North Falls Offshore Wind Farm Ltd – EN010119

Section 51 advice regarding draft application documents submitted by North Falls Offshore Wind Farm Ltd

On 24 May 2024 North Falls Offshore Wind Farm Ltd submitted the following draft documents for review by the Planning Inspectorate as part of its Pre-application Service¹:

Drawing Title  
**Work Plans (Onshore) - Sheet 15 of 16**

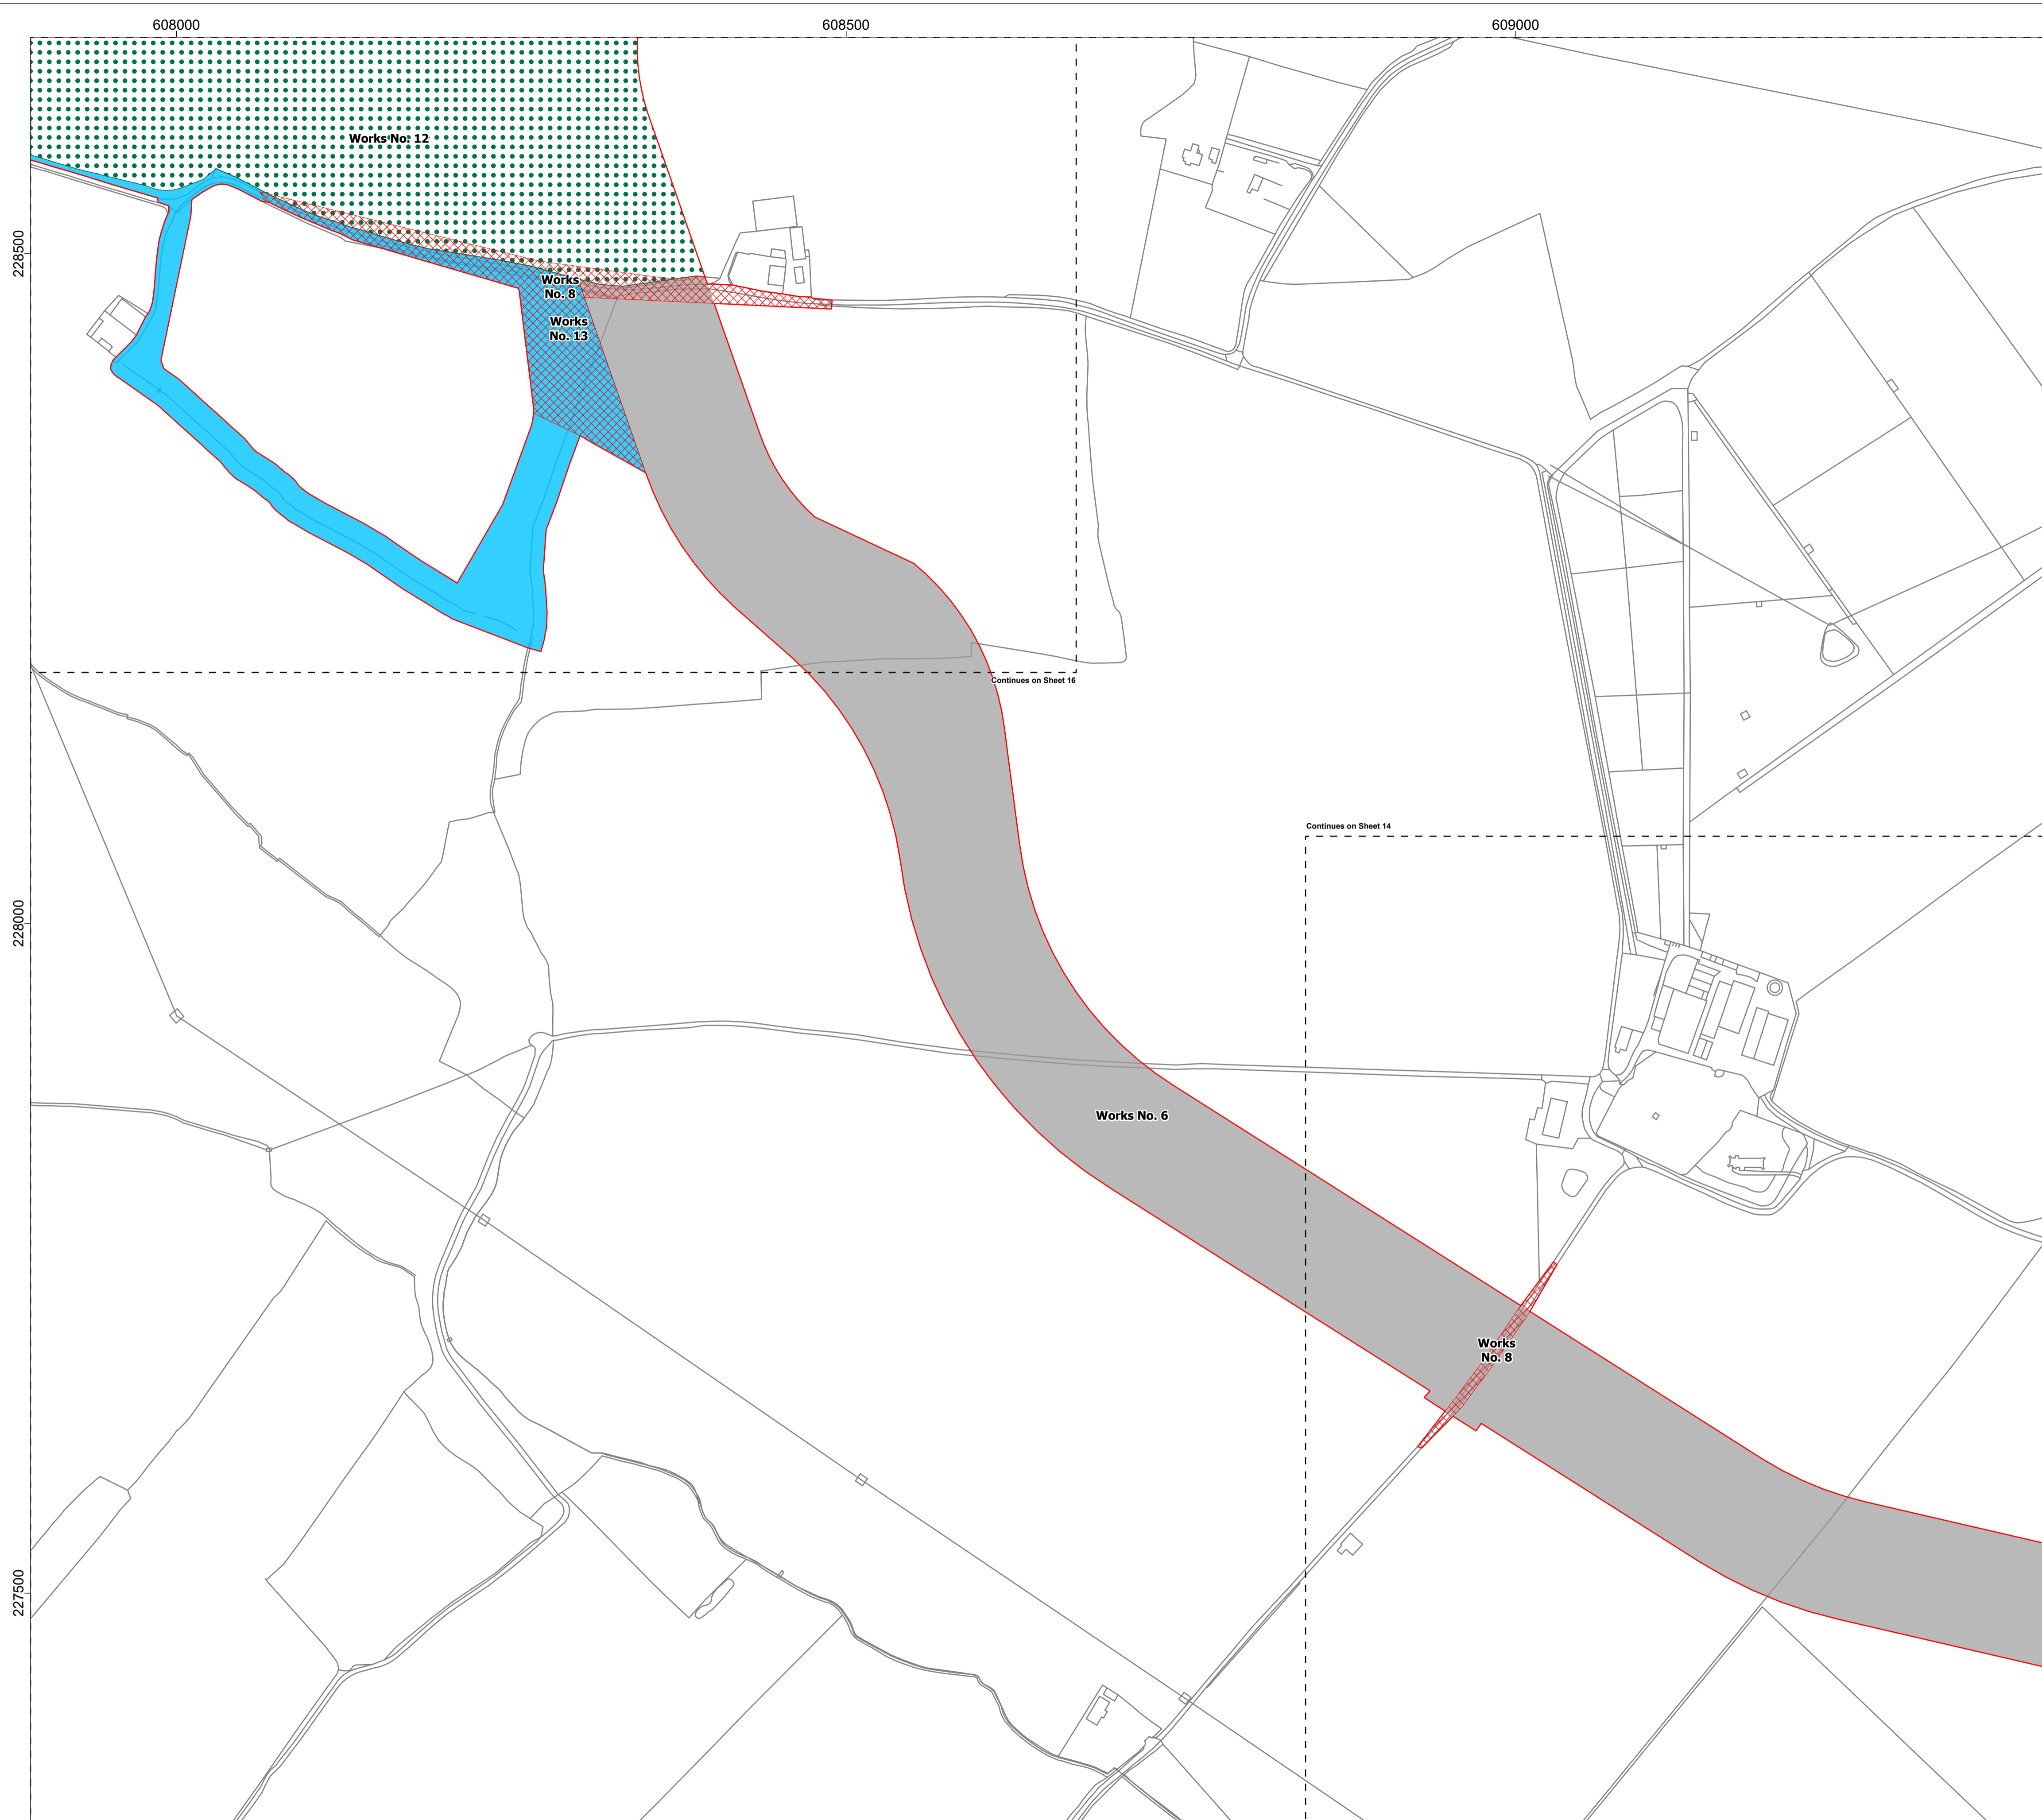
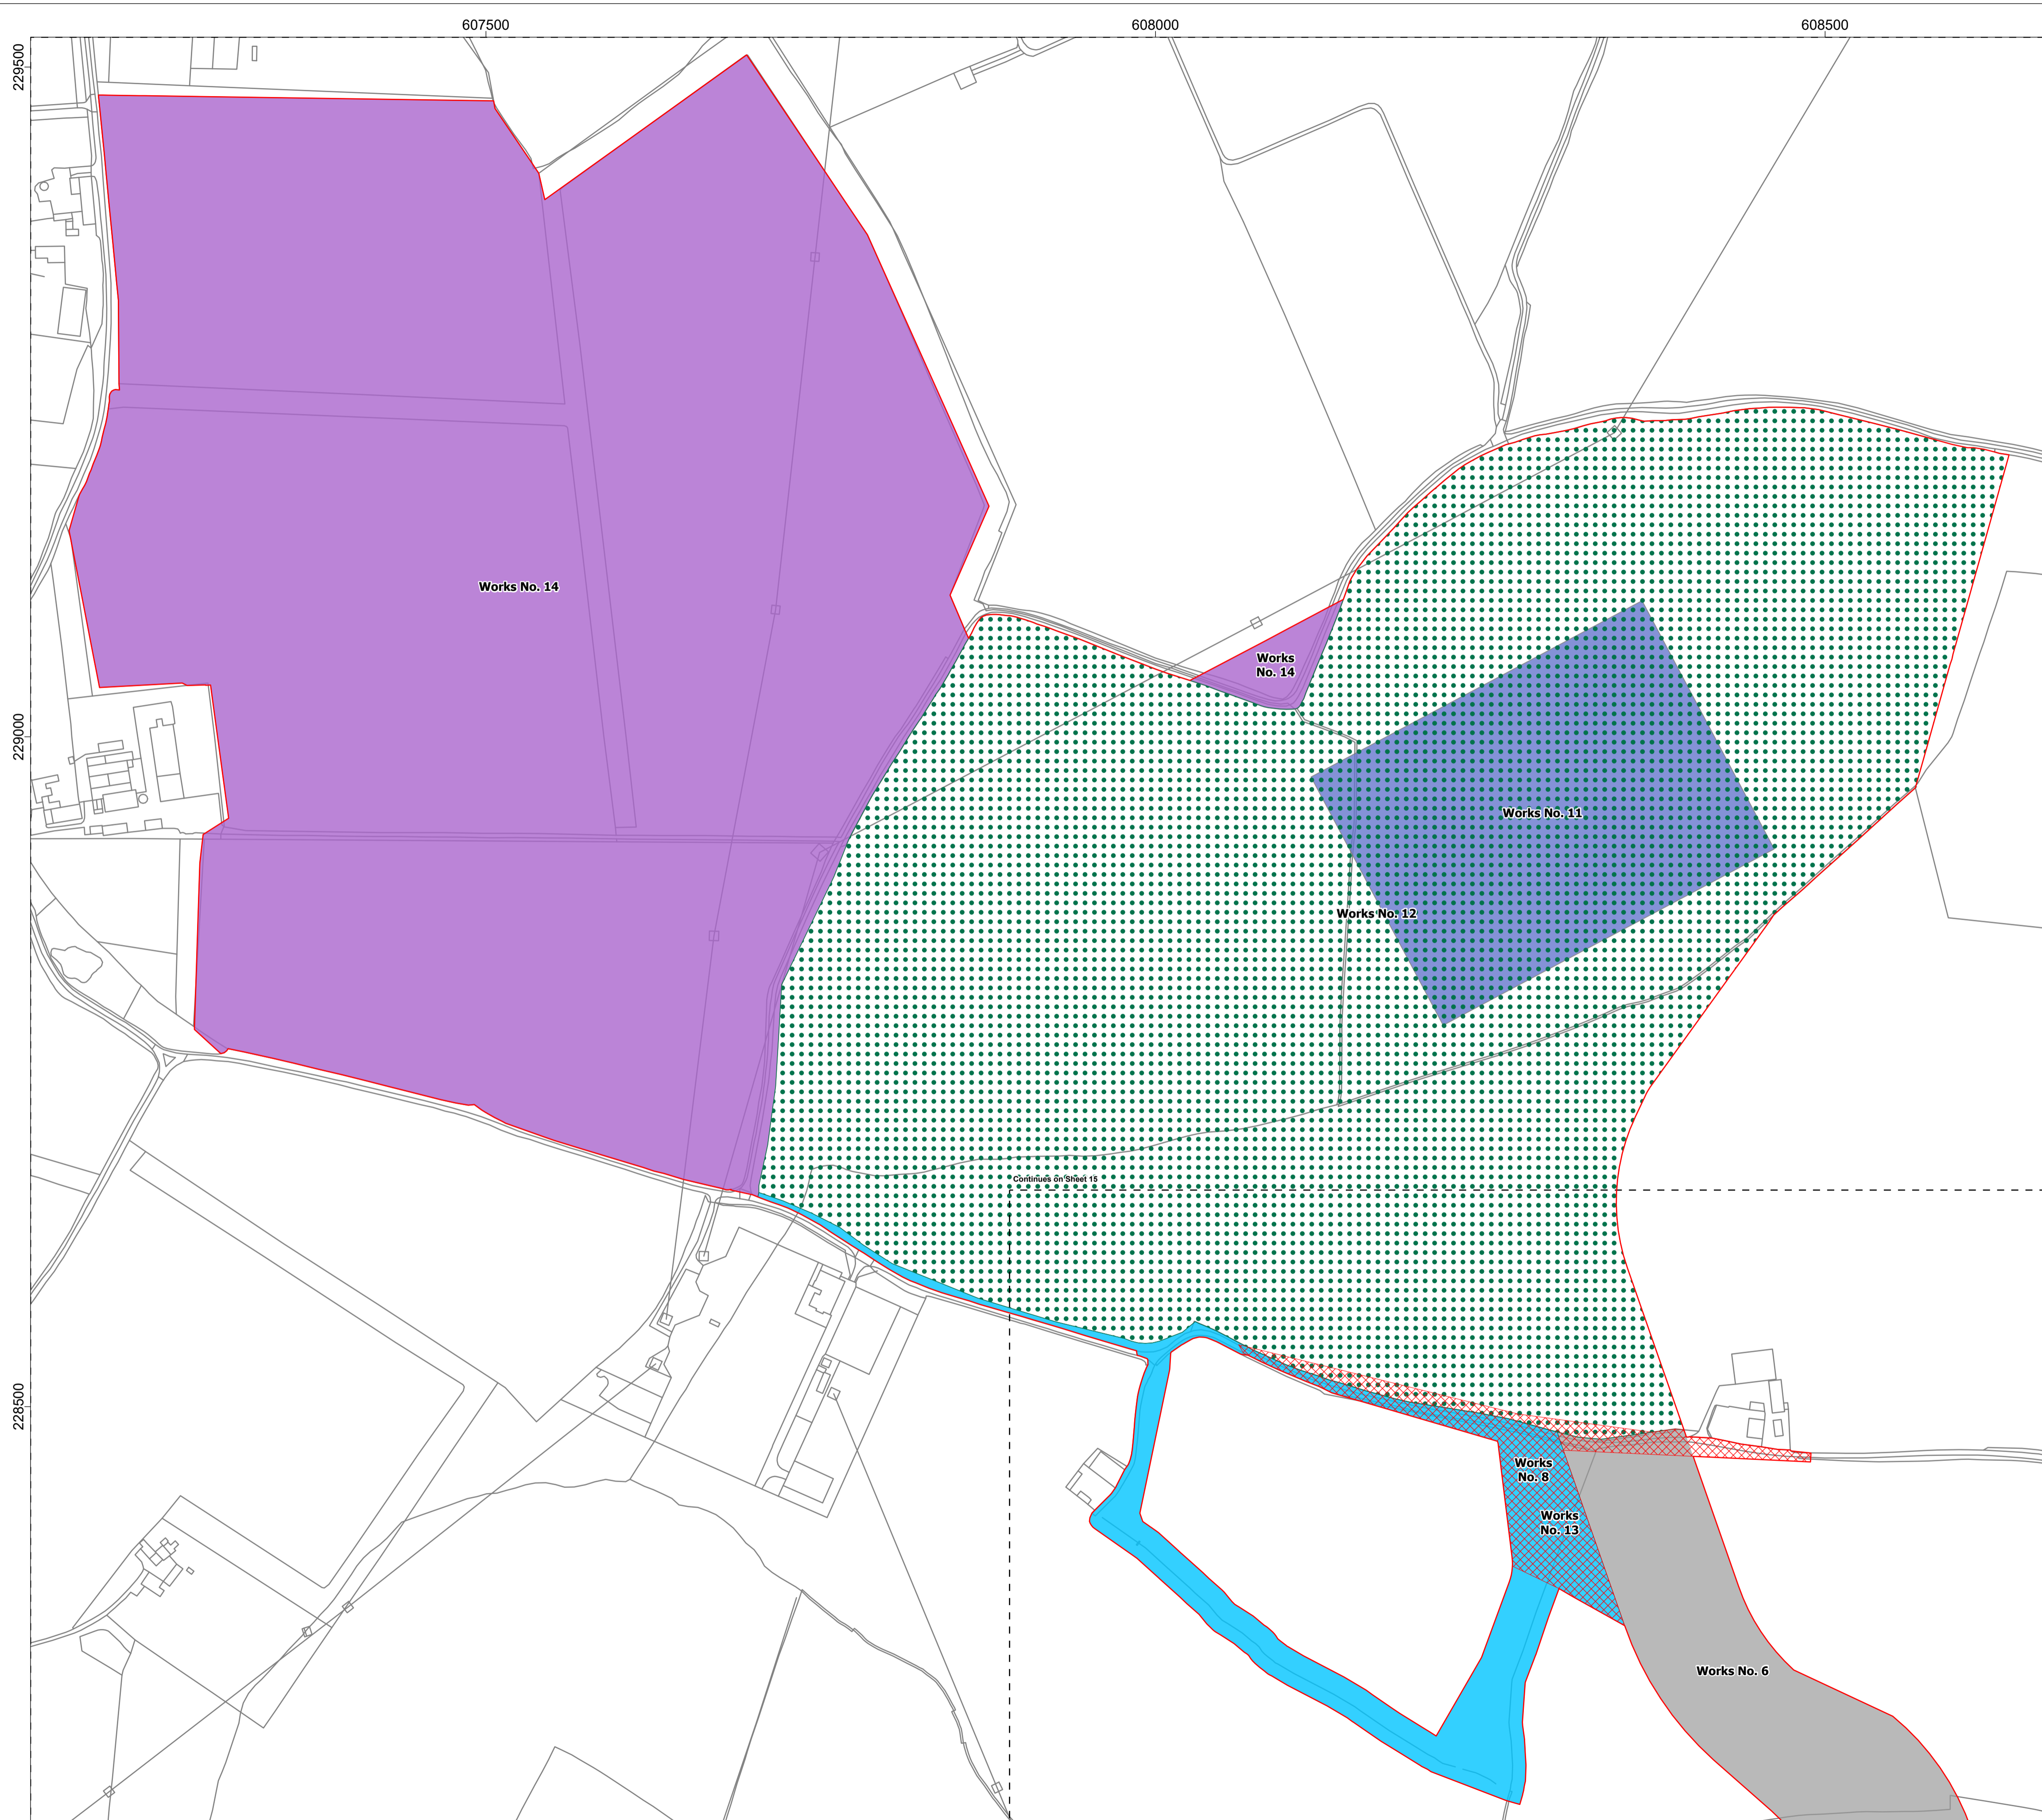
13.		The dDCO separates Works No. 12 down into 12A and 12B. It is not clear from the Work Plan which applies in each instance as only Works No. 12 is referenced. The Applicant may wish to consider distinguishing between Works No. 12A and 12B within the Work Plan.
14.		The dDCO separates Works No. 6 down into 6A and 6B. It is not clear from the Work Plan which applies in each instance as only Works No. 6 is referenced. The Applicant may wish to consider distinguishing between Works No. 6A and 6B within the Work Plan.
